**EL PASO COUNTY PLANNING AND
 COMMUNITY DEVELOPMENT
 DEPARTMENT**

GRADING AND EROSION CONTROL PLAN CHECKLIST

## GRADING AND EROSION CONTROL PLAN

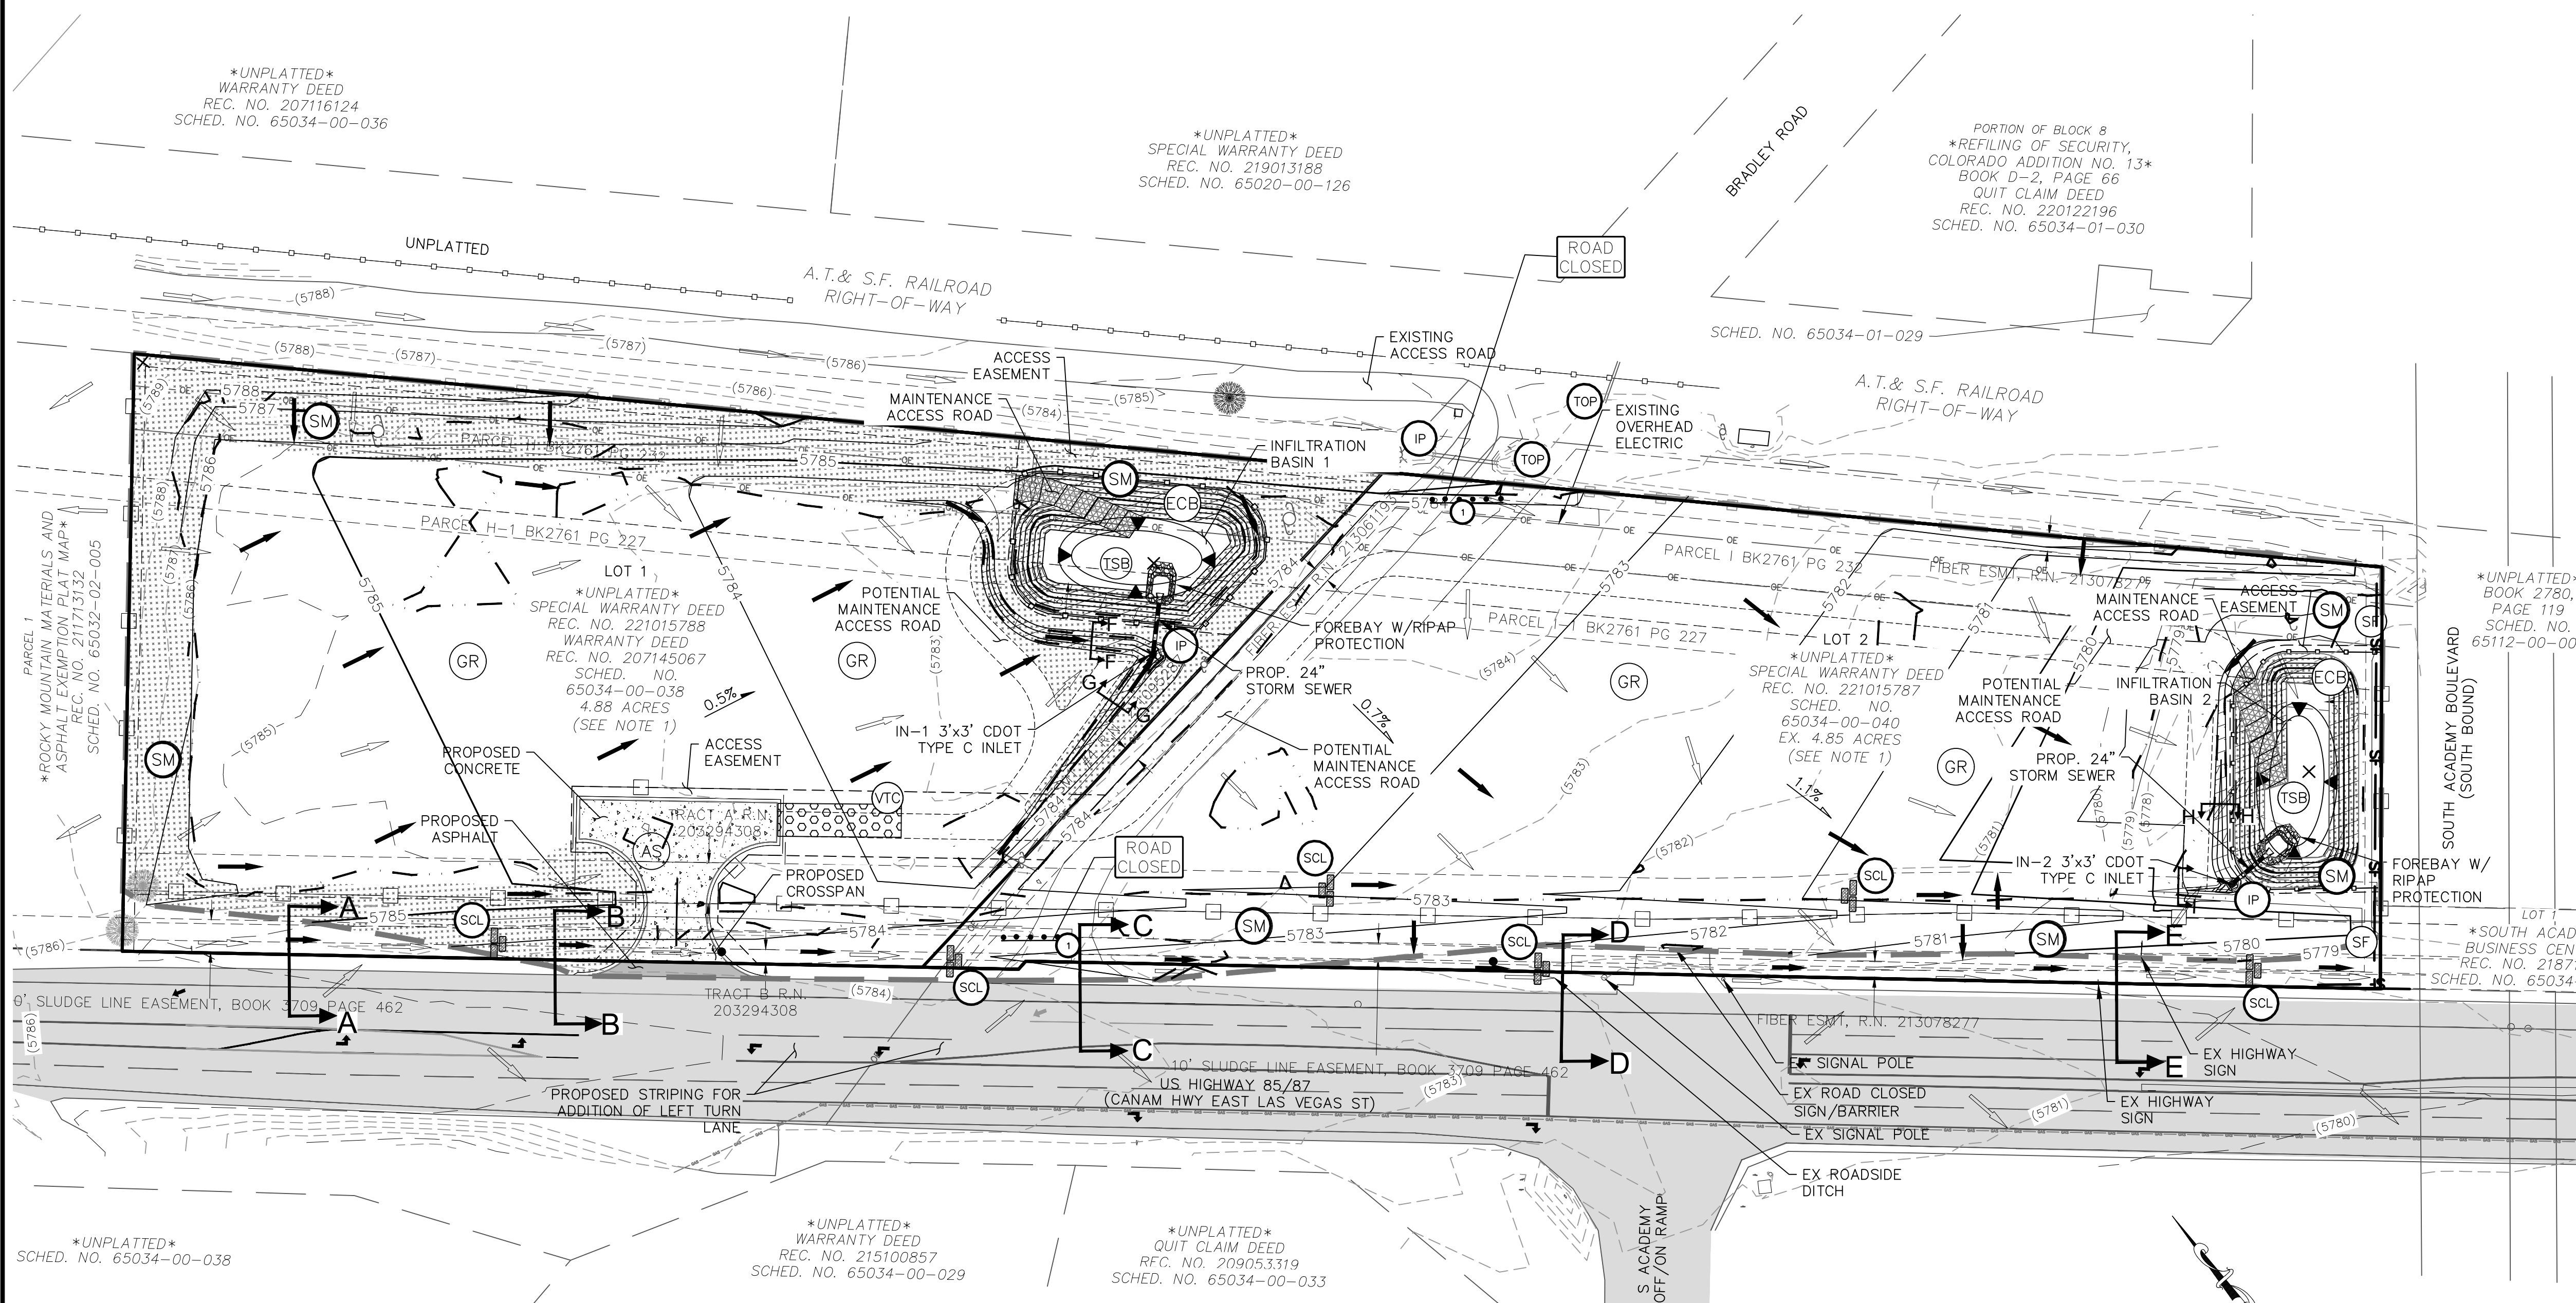
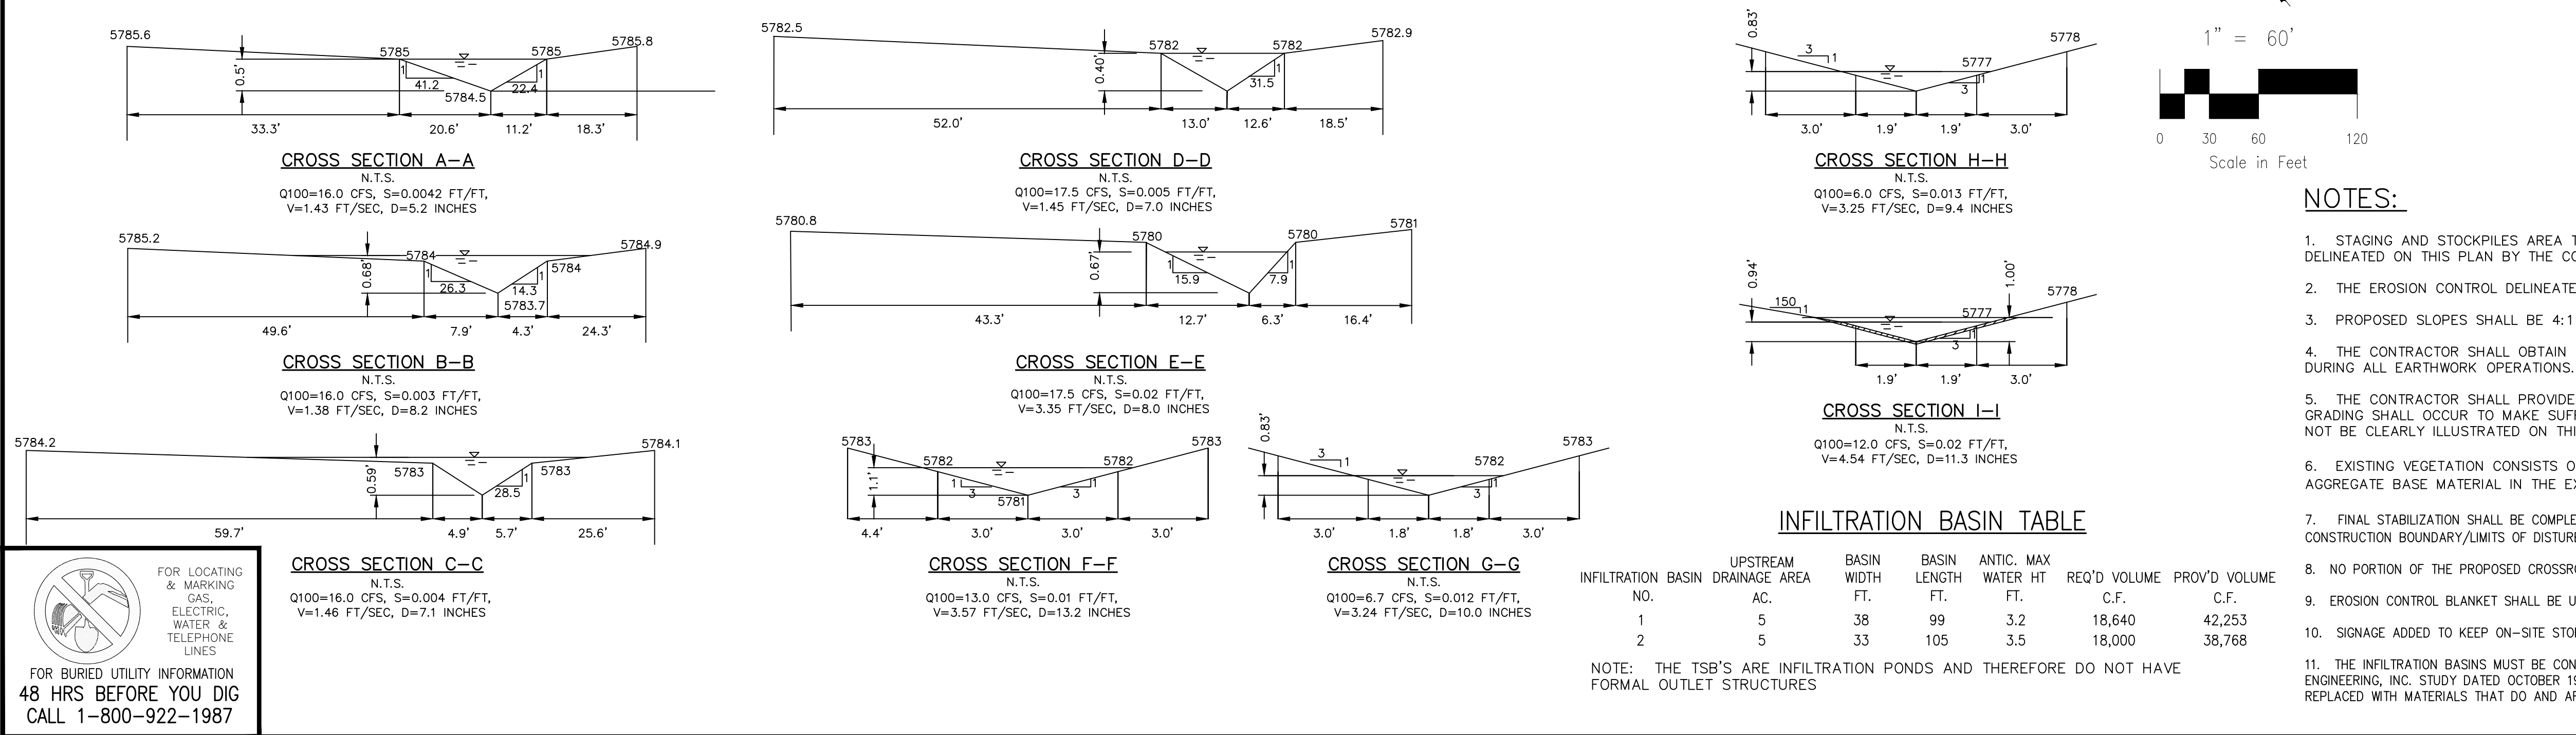
l	Existing and proposed contours 2 feet or less (except for hillside).	✓	✓
m	Limits of disturbance delineating all anticipated areas of soil disturbance.	✓	✓
n	Identify and protect areas outside of the construction site boundary with existing fencing, construction fencing or other methods as appropriate.	✓	X
o	Offsite grading clearly shown and called out.	✓	N/A
p	Areas of cut and fill identified.	✓	✓
q	Conclusions from soils/geotechnical report and geologic hazards report incorporated in grading design (slopes, embankments, materials, mitigation, etc.)	✓	✓
r	Proposed slopes steeper than 3:1 with top and toe of slope delineated. Erosion control blanketing or other protective covering required.	✓	N/A
s	Stormwater flow direction arrows.	✓	✓
t	Location of any dedicated asphalt / concrete batch plants.	✓	N/A
u	Areas used for staging, storage of building materials, soils (stockpiles) or wastes. The use of construction office trailers requires PCD permitting.	✓	✓
